DECISION DELEGATED TO HEAD OF PLANNING

Application No: H15-0557-23 **Applicant:** Mr P Green

Proposal: Details of wildlife survey, contamination of land or pollution of controlled waters, foul/surface water disposal, landscaping & tree planting, proposed boundary treatments, design of external doors & door frames, window frames and proposed roof light(s). (Conditions 3, 4, 5, 6, 7, 8, 9 and 10 of H15-0100-21)

Location: Judy Cross Barn Watergate Quadring

Figure 3

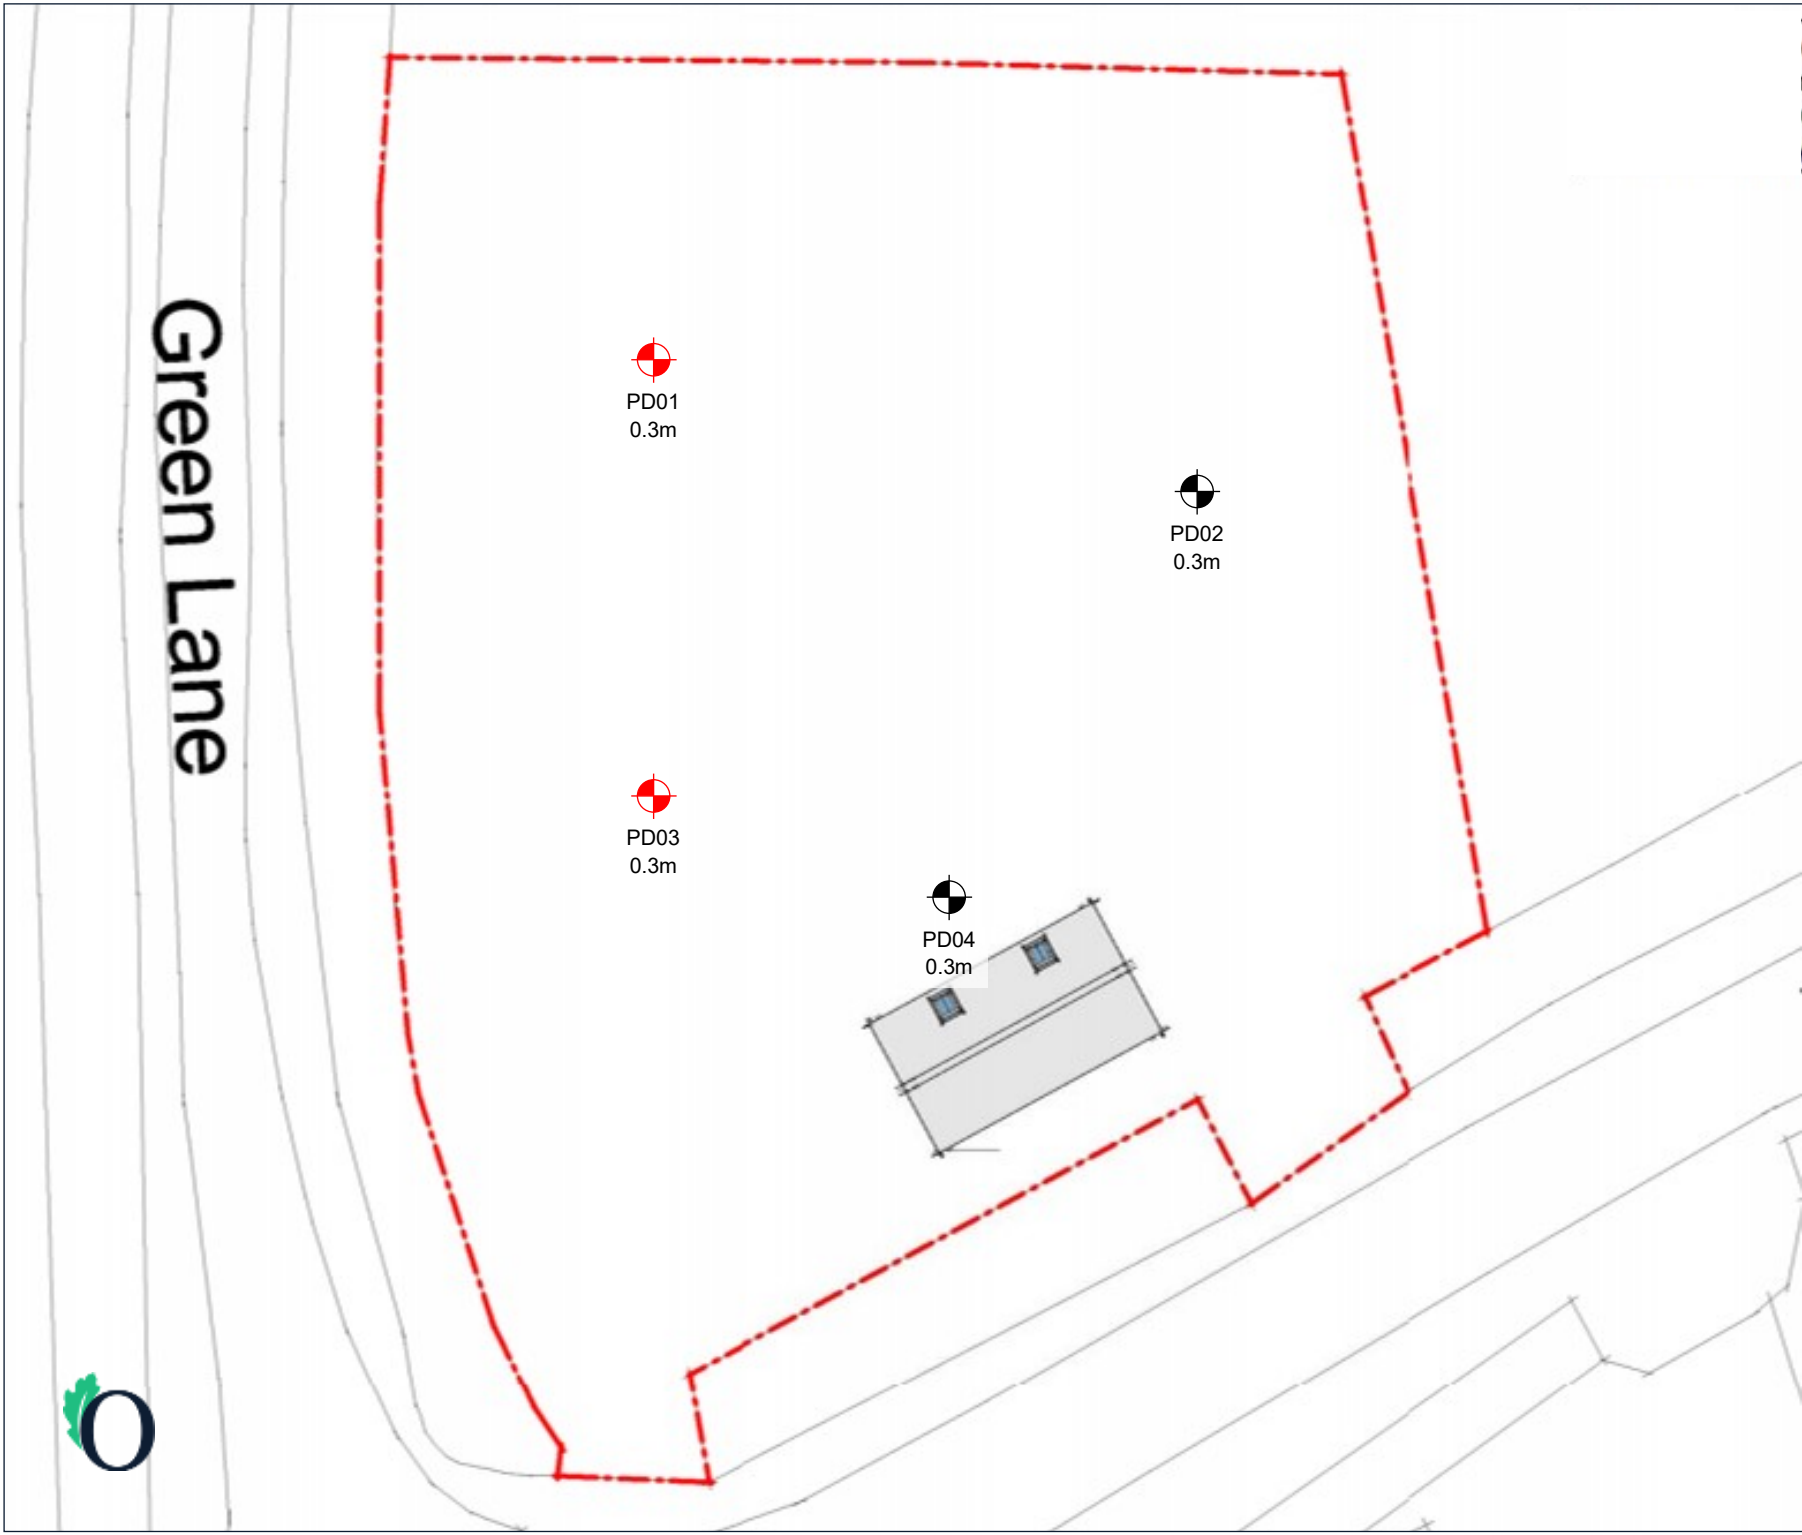
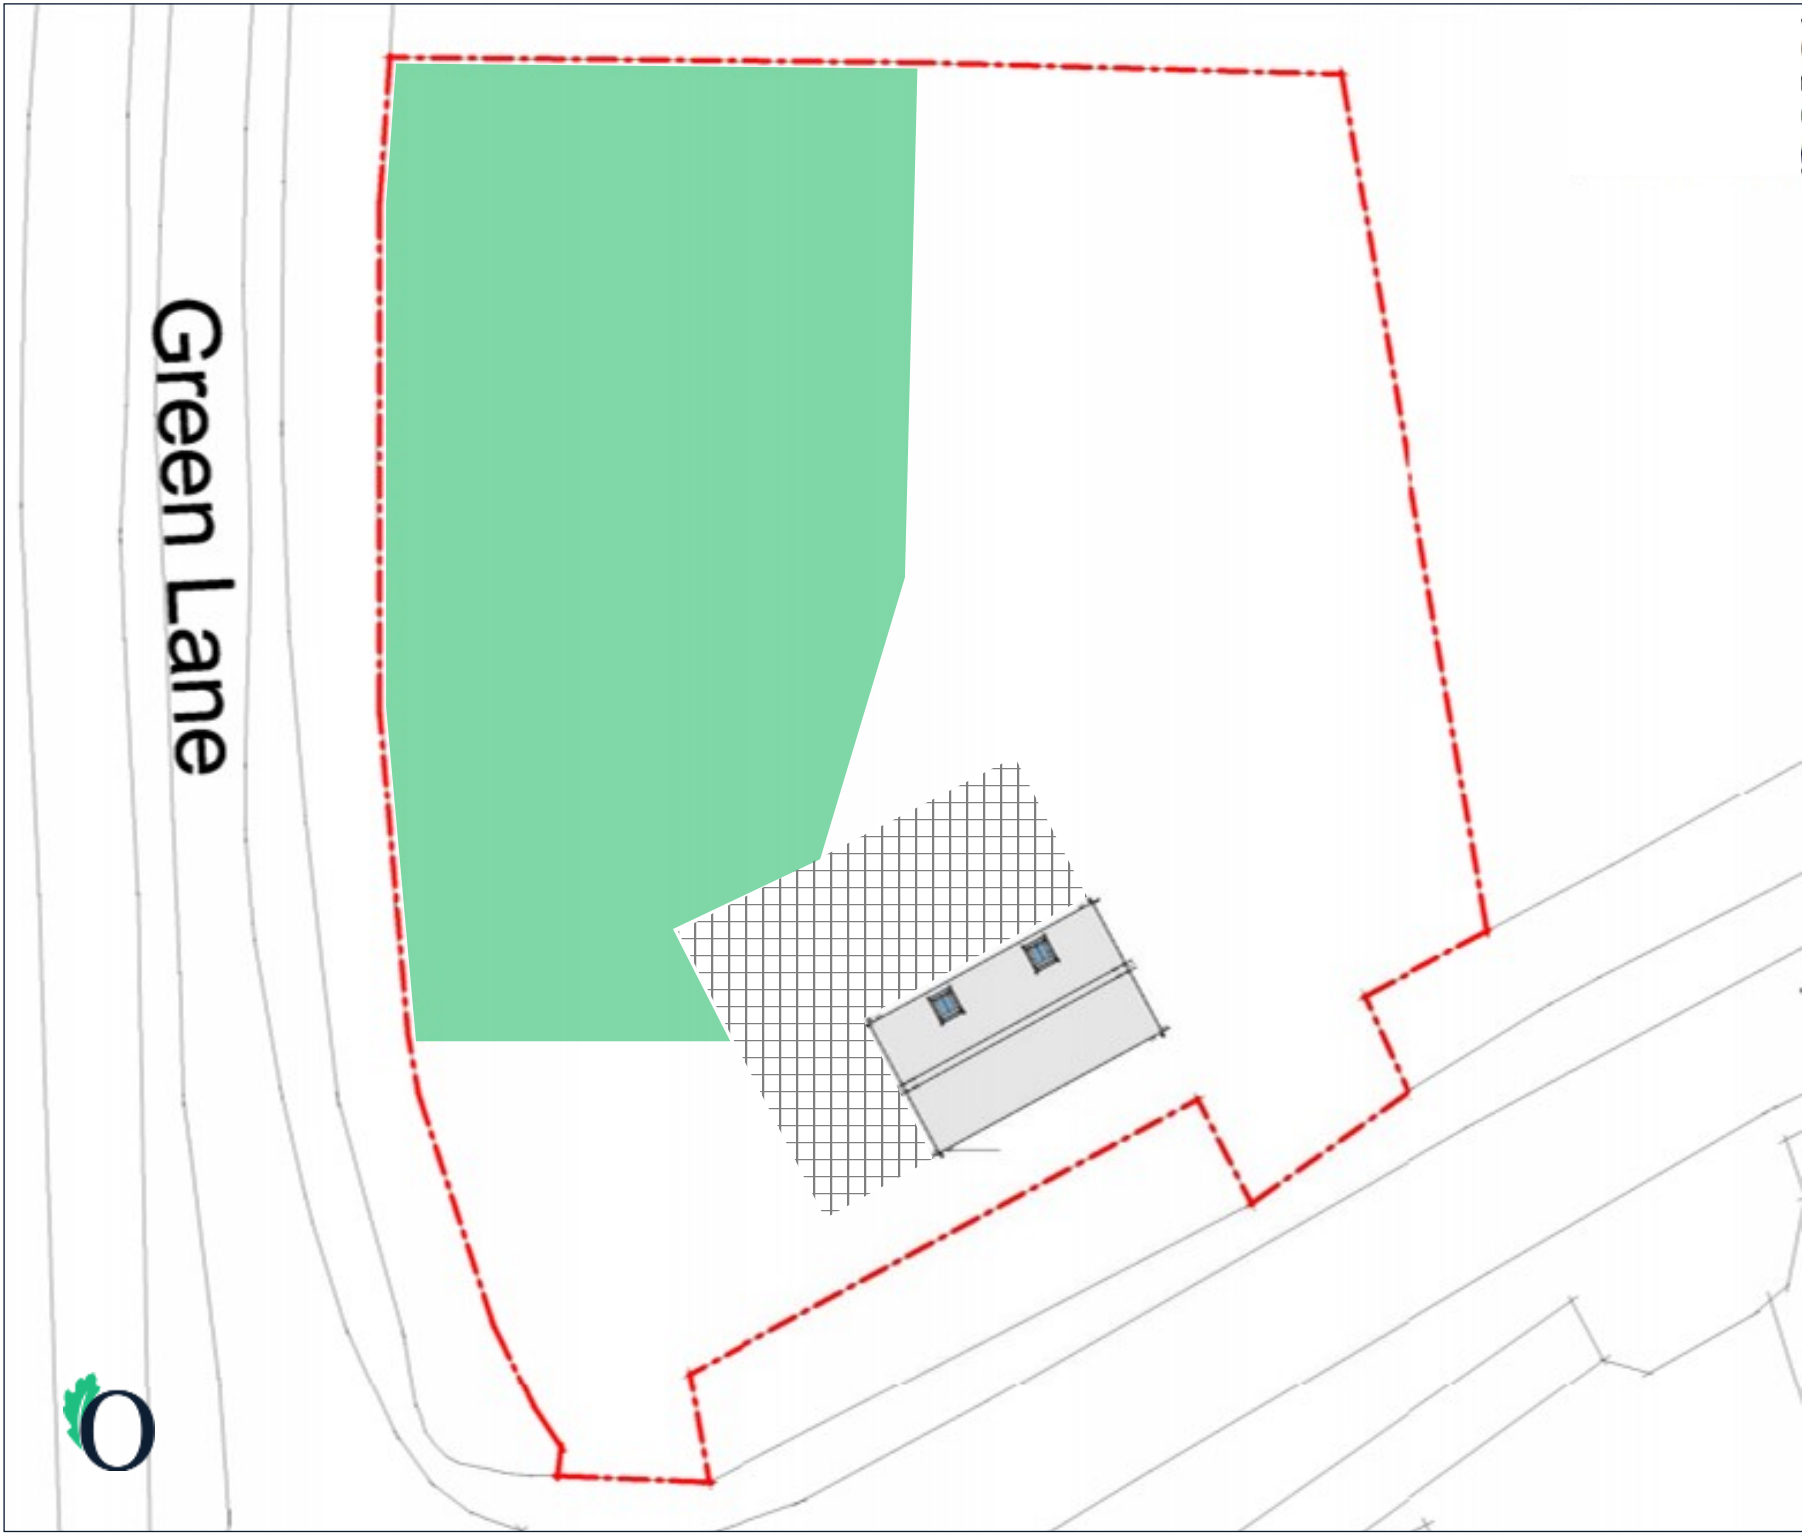
I have reviewed the Oakshire Environmental Report 'Phase 3 Remediation Options Appraisal Judy Cross Barn, Water Gate, Quadring, Spalding PE11 4PY' dated 10 February 2022. Two options were discussed - breaking the pathway by either clean cover or a physical barrier, with 600mm clean cover suggested as the consultants preferred solution. In theory, either option is acceptable, however I feel that there are too many uncertainties at this point to agree the remediation strategy proposed in section 5.2.

In particular, there is no rationale to explain how the area to be covered by the remediation has been determined. There is no physical identifier to delineate either the area or depth affected. The report assumes that soil below 300mm and outside of the proposed remedial area does not contain elevated levels of determinants, but there is no evidence to support this decision.

I consider that either a wider remediation, or further sampling to delineate the area is required.

The Environmental Protection Team responded to this application confirming that they were satisfied with the discharge of parts i & ii of Condition 4, requesting that either a wider remediation or further sampling be taken out to be able to discharge parts iii & iv. Upon consideration of this request, the Local Planning Authority considers this to be unreasonable, given the low risk of land contamination at this site, as identified in the Oakshire Report and the nature of the former use as a simple agricultural barn. The LPA therefore notes and concurs with the findings of the Oakshire reports and recommends that this condition may be discharged.
